CITY OF ALBUQUERQUE

April 7, 2022

RE: Saranam Golf Course & Montano
4701 Montano Rd NW
Grading and Drainage Plan
Engineer's Stamp Date: 2/15/2022
Hydrology File: E11D013B

Based upon the information provided in your submittal received 2/16/2022, the Grading & Drainage Plan **is not** approved for Building Permit. The following comments need to be addressed for approval of the above referenced project:

ENGINEER'S SEAL	SARANAM AT 4701 MONTANO RD NW BASIN MAP PLAN	DRAWN BY LN
			DATE 10/20/2021
			2019080_GRE
			SHEET # C2.1 JOB # 2019080

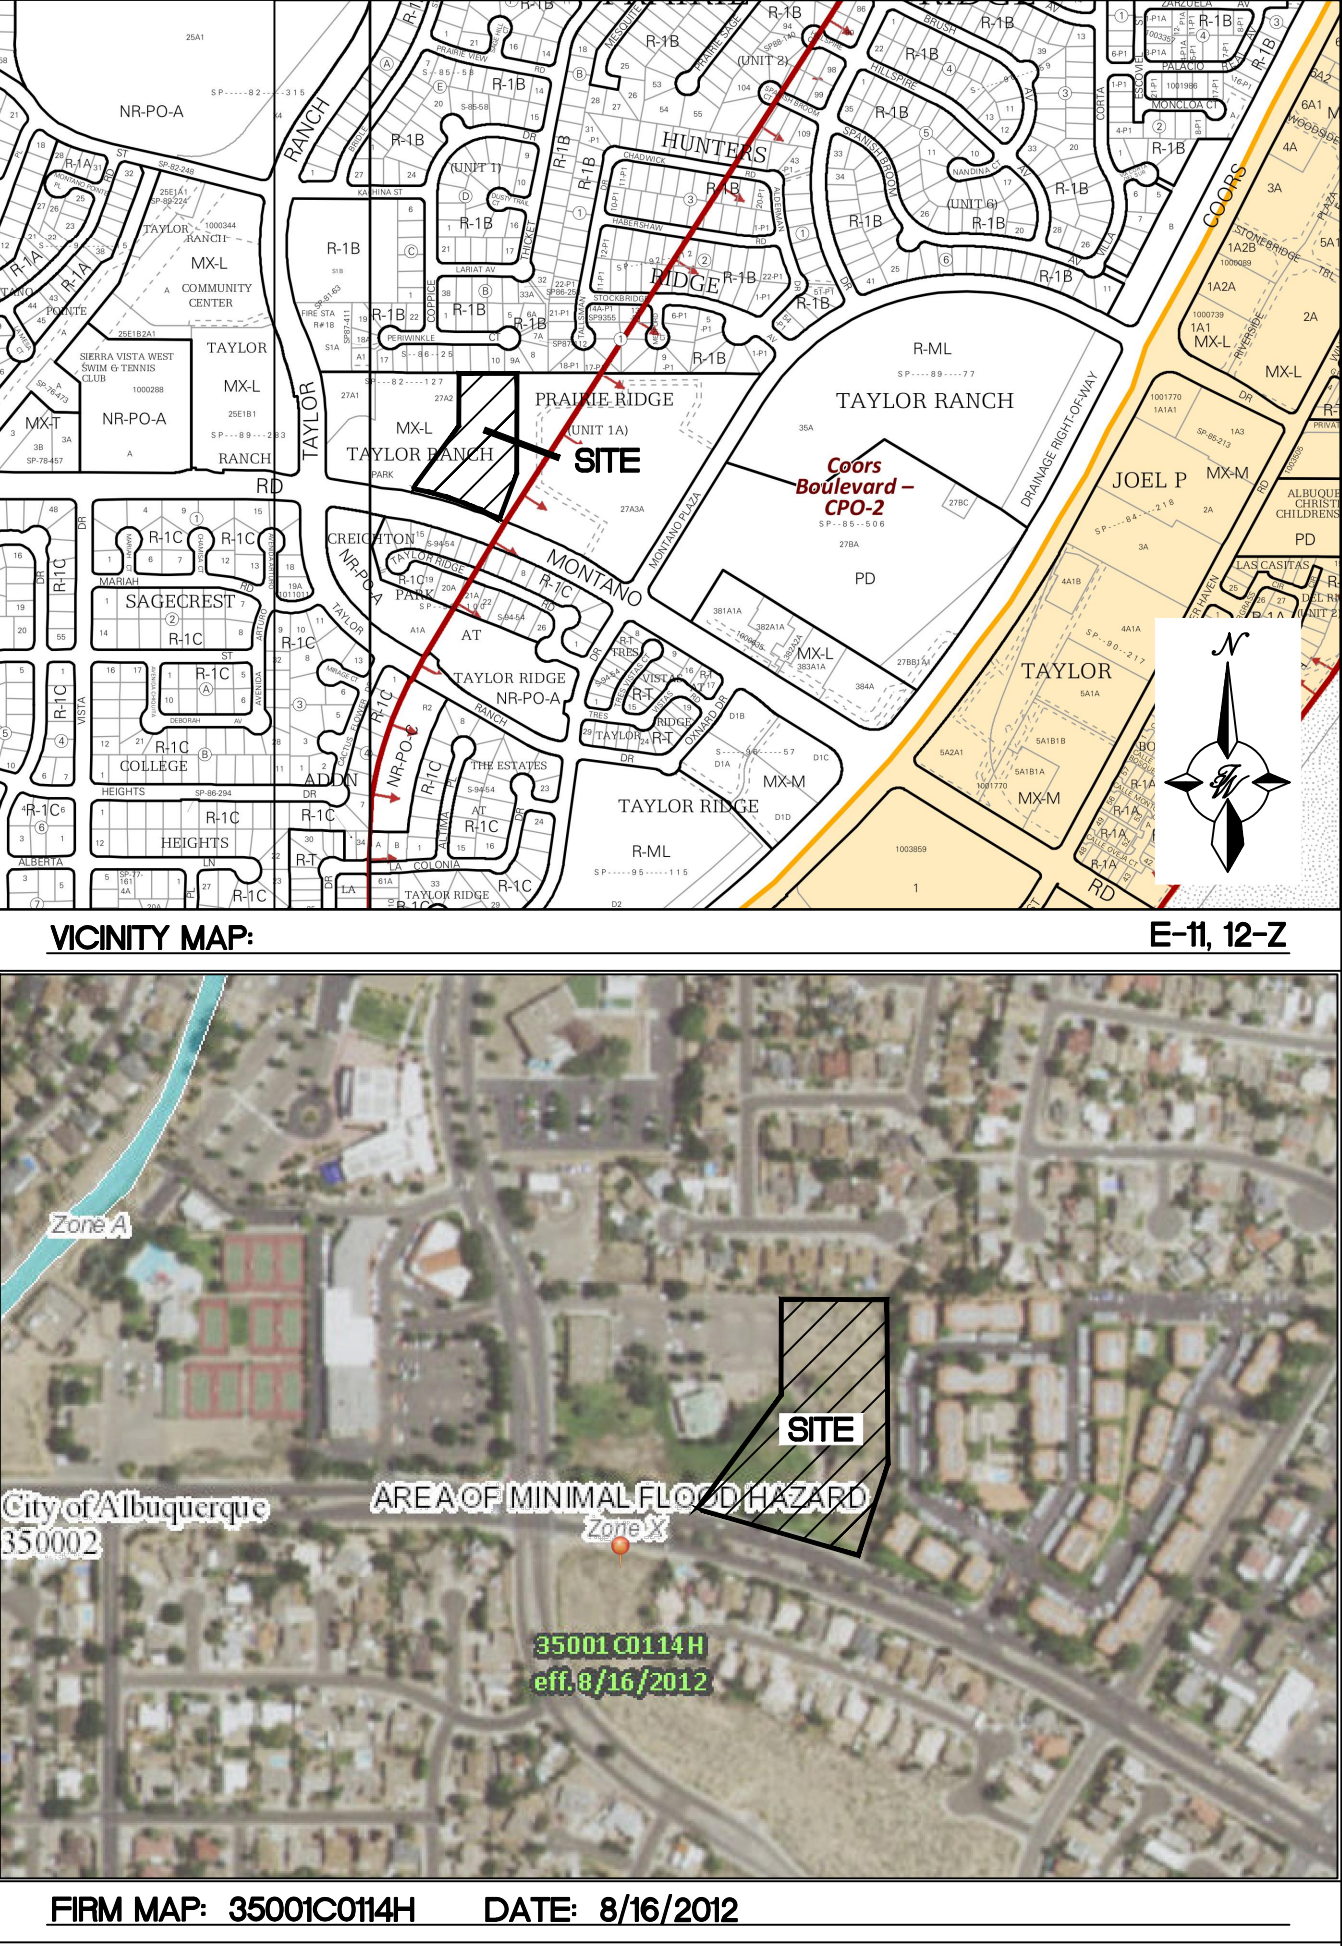
1. The Basin Map does not appear to reflect the same buildings as the G&D Sheets.
 - a. Additionally, it appears flow is directly differently.
 - b. Ensure cross lot drainage is established (easement) if that is the plan and show how this will be routed to the proper location overall. We need to know where the water ends up ultimately.

2. Please utilize new DPM revision Chapter 6.
3. It appears the overall flow should end up in the lake and should be retained if possible. Please provide retention calculations (100-year storm event for 10 days) and show how this volume will be contained on-site.

1. Please double check the calculations for the tables provided. I checked a couple and did not come up with the same.
2. Please include the required volume for retention. (100-year, 10-day storm)

Response: See updated sheet C2.1, basin maps updated to reflect latest changes to site plan and grading. Tract 27-A-2A (Project site) is to drain to the large retention pond located just west of site via an 18" HDPE pipe located within a 20' drainage easement granted under DOC# 202101455 (attached).

Response: See updated sheet C2.1, the proposed 100 yr. - 10 day storm volume was calculated and is the design storm. According to as-builts under hydro file E11_D13A (Attached) the existing retention pond/lake west of the site has enough capacity to retain the proposed design storm volume.

1. Please double check the calculations for the tables provided. I checked a couple and did not come up with the same.

Response: Calculations updated to new DPM chapter 6 requirements.

2. Please include the required volume for retention. (100-year, 10-day storm)
Response: Required volume included in sheet C2.1.

SHEET #
C2.2

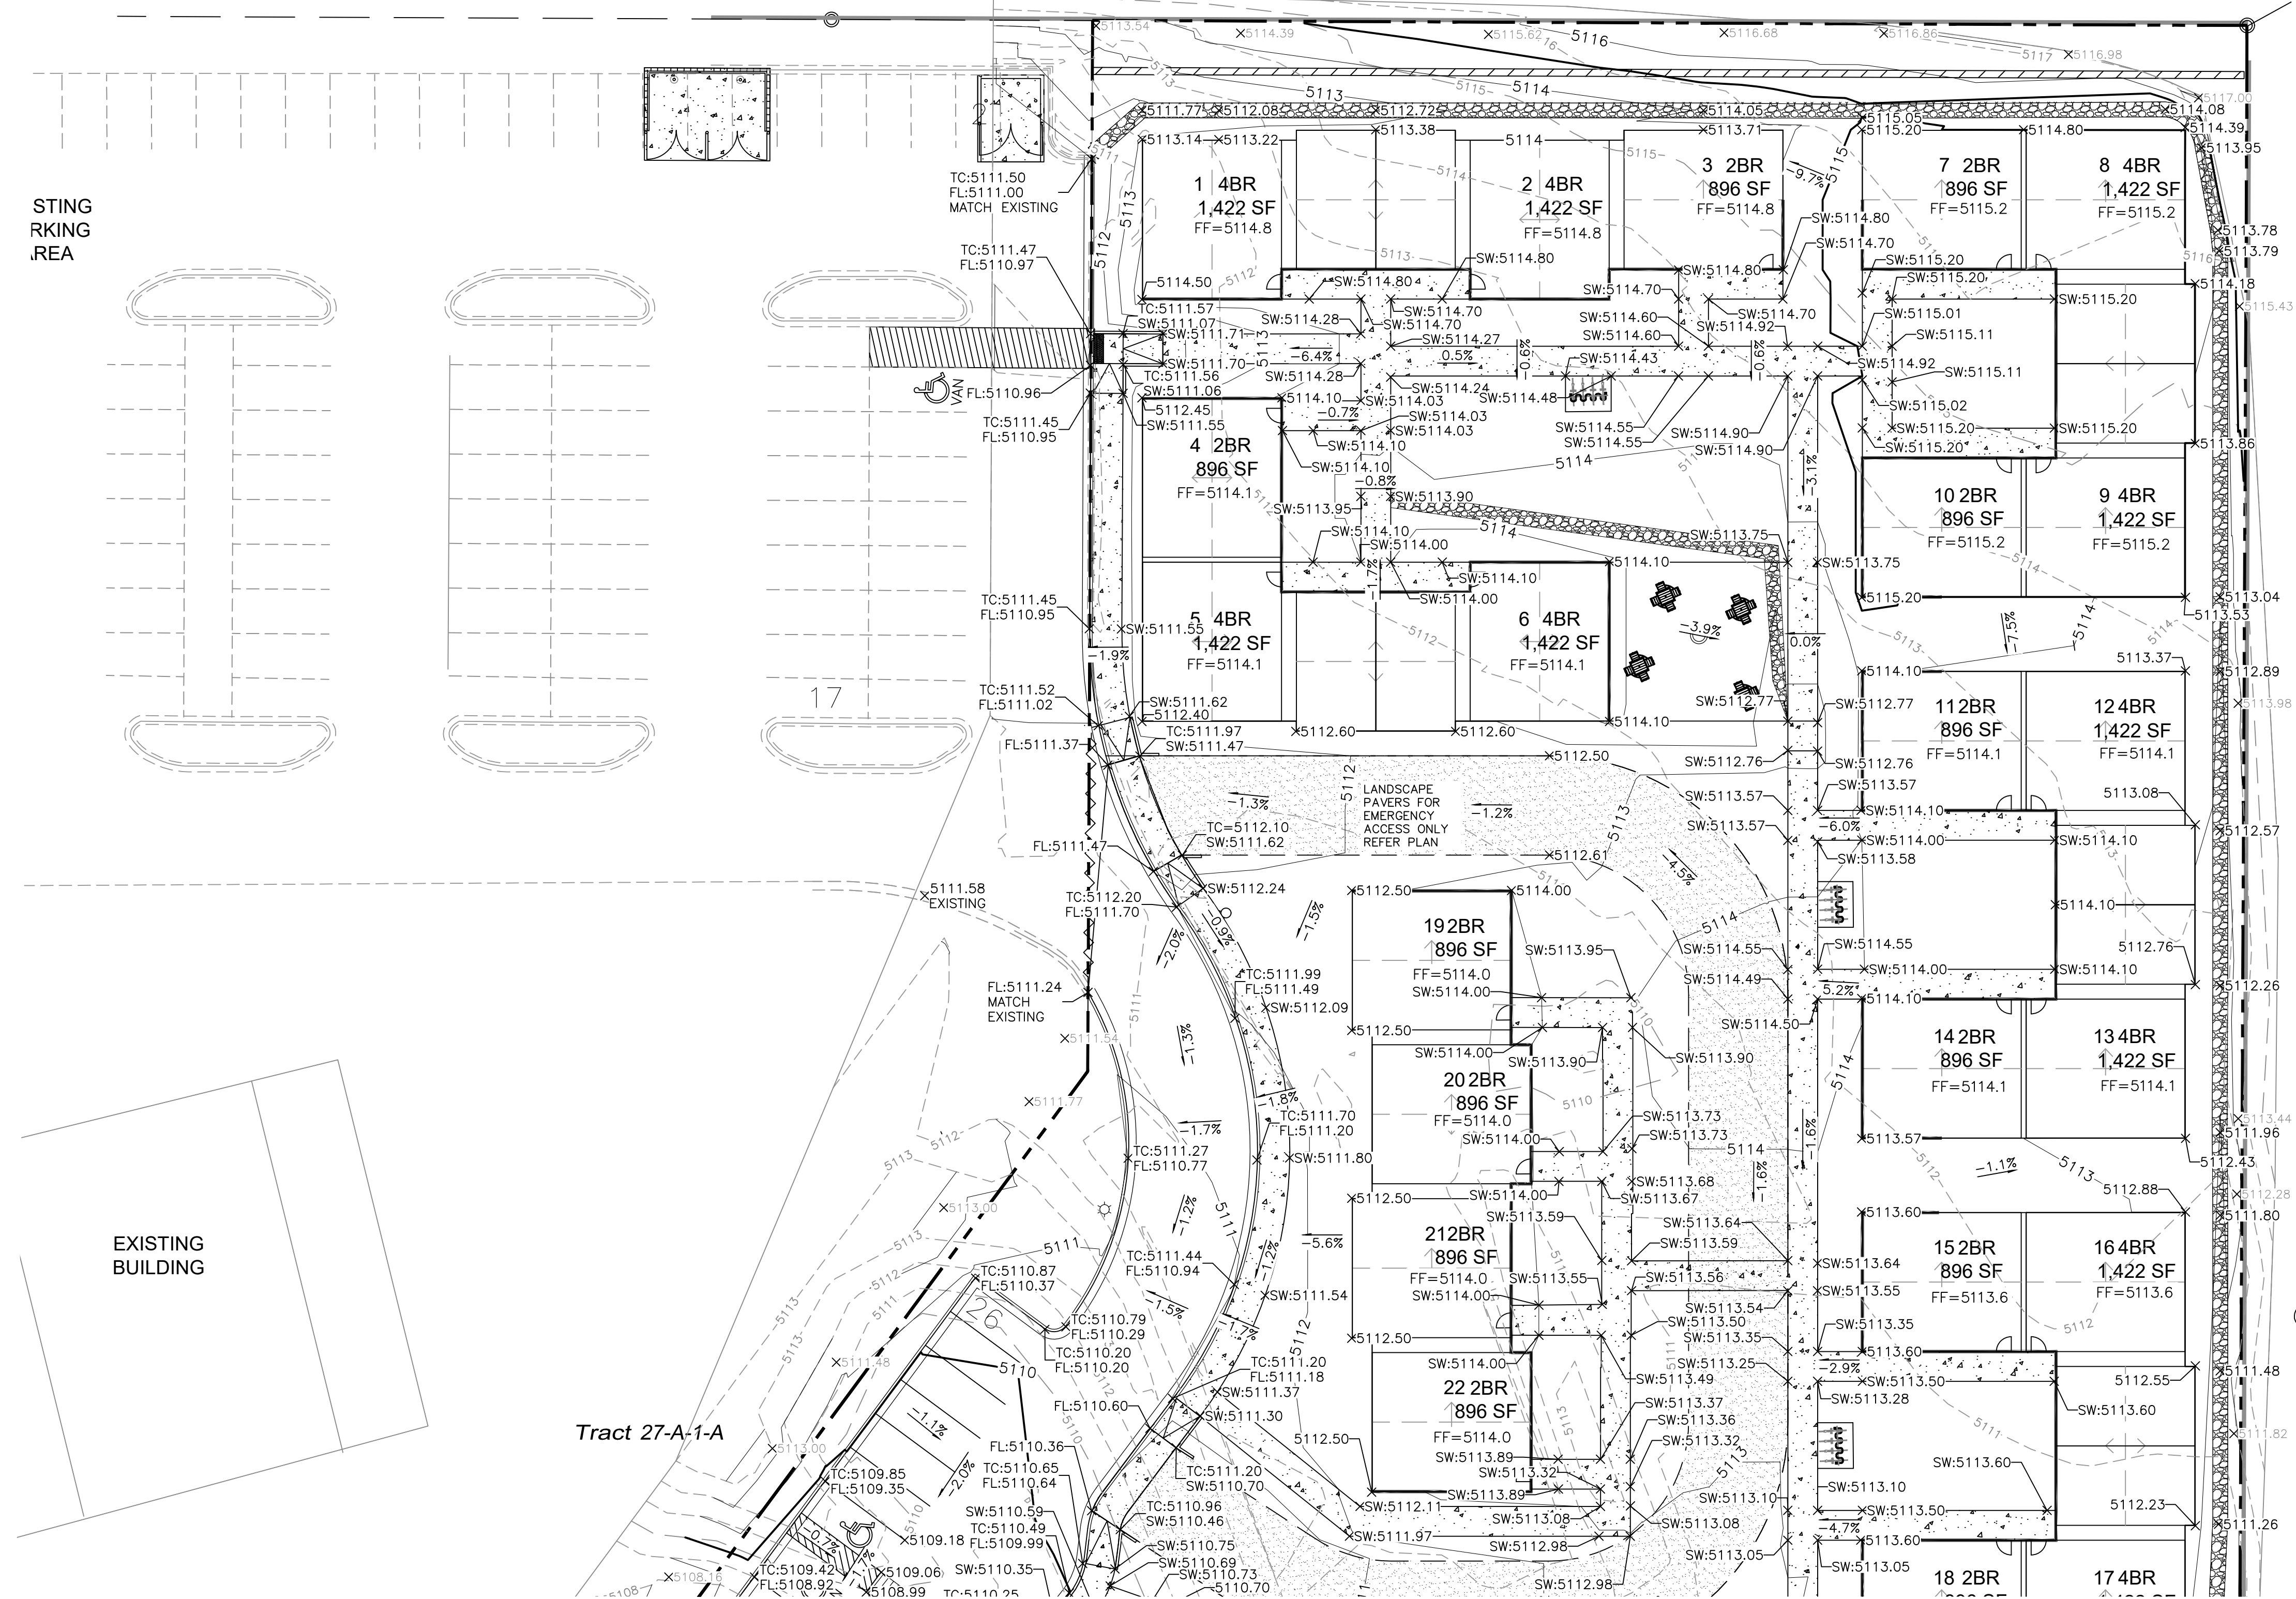
4. Check FF vs corner spot elevations. They do not match.
5. Call out all pipes and materials.
 - a. Show invert elevations.
6. Swales
 - a. Provide elevations to show how they flow.

- b. Provide section and reference to each one.
7. Overall the site needs to have a close review to ensure all of the shown elevations work.
 - a. If the elevation here is correct the flow is going right into the building?

5. Check out all pipes and materials.
 - a. Show invert elevations.
Response: Only one pipe proposed on the southwest side of site see sheet C2.2. Pipe material, slope and invert elevations called out.

6. Swales
 - a. Provide elevations to show how they flow.
 - b. Provide section and reference to each one.
Response: Swale section and call outs are shown on sheet C2.2, swale elevations shown on sheets C2.3 and C2.4.
